November 7, 2007

RE: Esencia Subdivision L8/D016, Conceptual Grading Plan Approval

The conceptual grading plan for Subdivision L8/D016 project does not provide the necessary information to determine the impacts to the City of Albuquerque. There are some concerns with the proposed plan that should be addressed in the drainage report for the project.

ESENCIA CONCEPTUAL GRADING AND DRAINAGE PLAN			
DRAWING:	DRAWN BY:	DATE:	SHEET #
200618-GR.DWG	SBB	10-15-07	3.2 OF 4

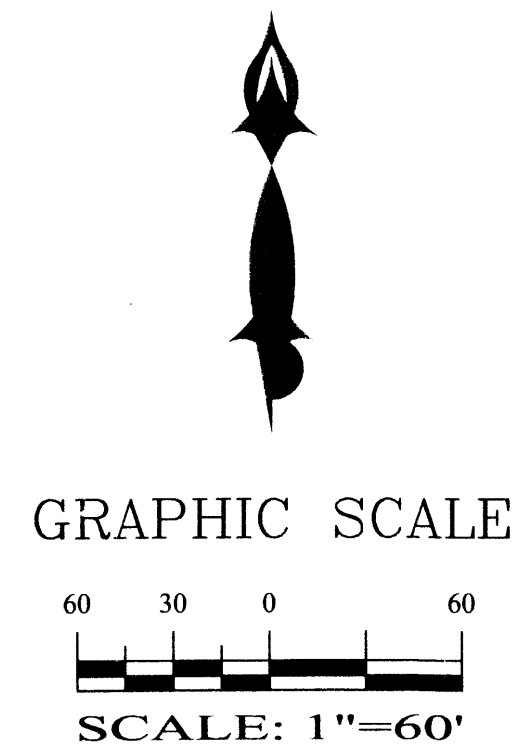
- Does Bernalillo County accept creating permanent retention basins within the 118th Street right of way? This may impose restrictions on future street

widening projects. In addition, do these retention areas require infiltration into the road base?

ESENCIA CONCEPTUAL GRADING AND DRAINAGE PLAN			
DRAWING:	DRAWN BY:	DATE:	SHEET #
200618-GR.DWG	SBB	10-15-2007	3 OF 4

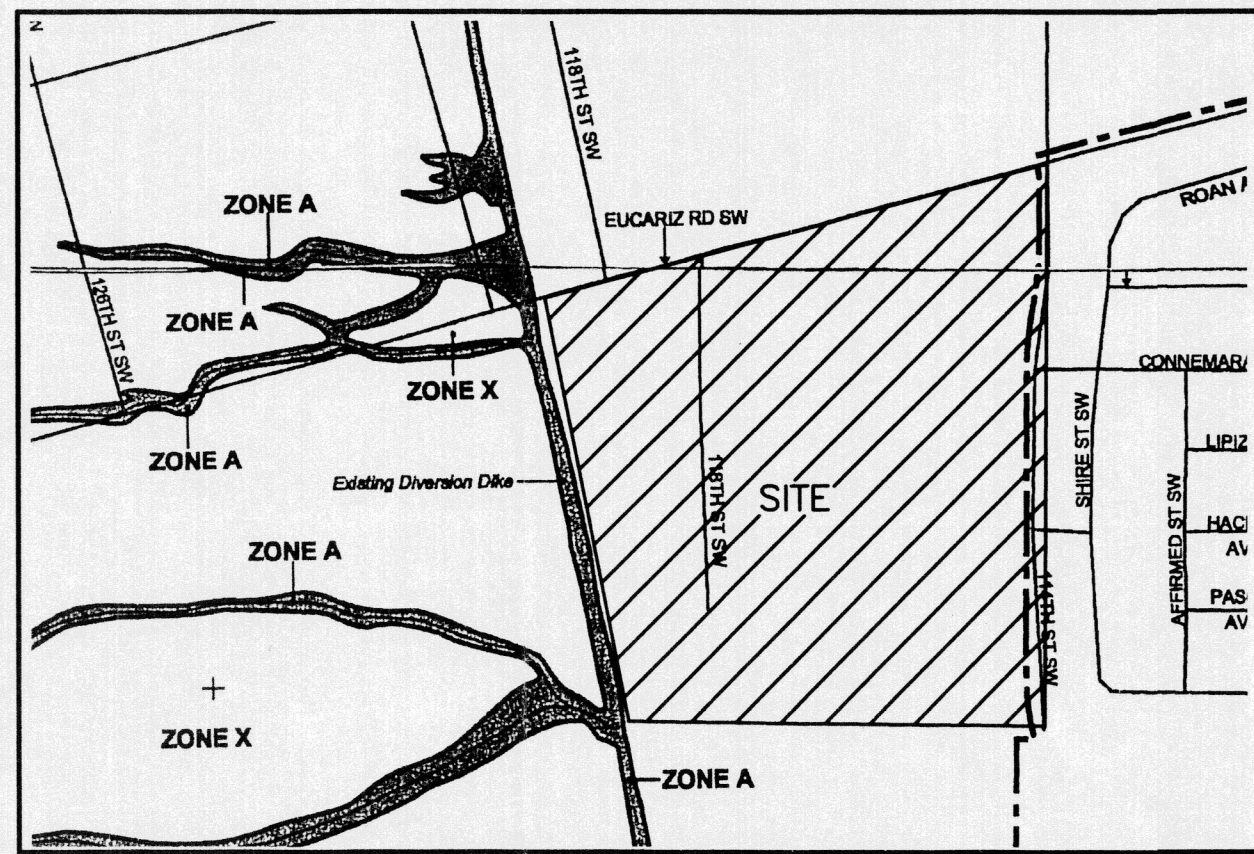
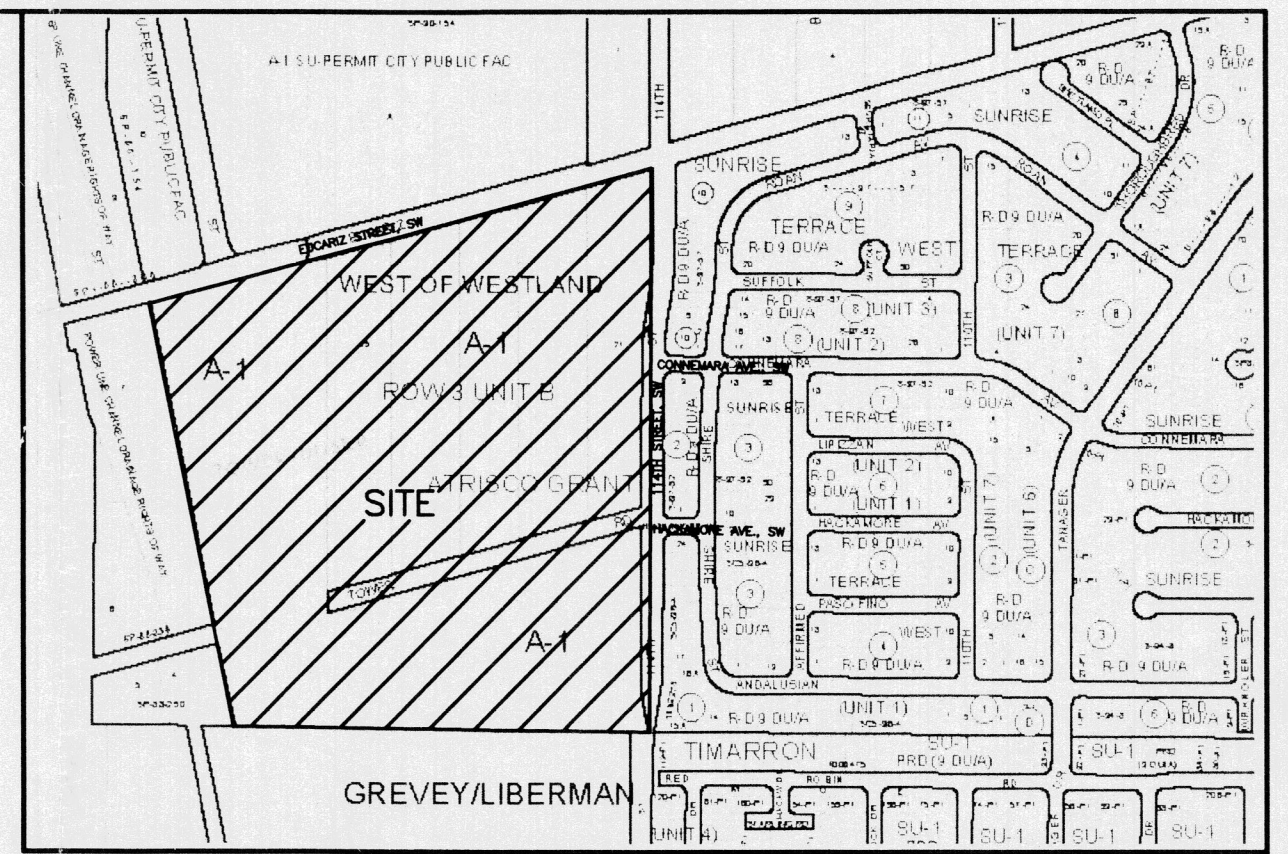
- It should be noted that the proposed detention basin appears to require greater storage than represented in the drawings and AHYMO input files. The current proposal assumes full orifice flow with no downstream constrictions and allows for the flooding of an entrance to the subdivision.

- It appears that the basin was sized only using a six-hour storm. Incorporating a larger storm for detention basin sizing may require increased storage.

- The northern lots appear to drain to the back of the lot rather than to the street at the front. It is not apparent how this drainage area will enter the City of Albuquerque storm drainage system.

- Why is drainage for 118th Street not to be contained within the proposed retention basins? How will this drainage affect the City of Albuquerque storm drainage system.

- There are streets with slopes in excess of 4%. Please note that momentum components of flow must be analyzed to determine if the flow will remain within the street and not exit through curb cuts.
- Show a cross section through the proposed 32' high retaining wall.
- Lot elevations at all corners should be shown with drainage direction shown.
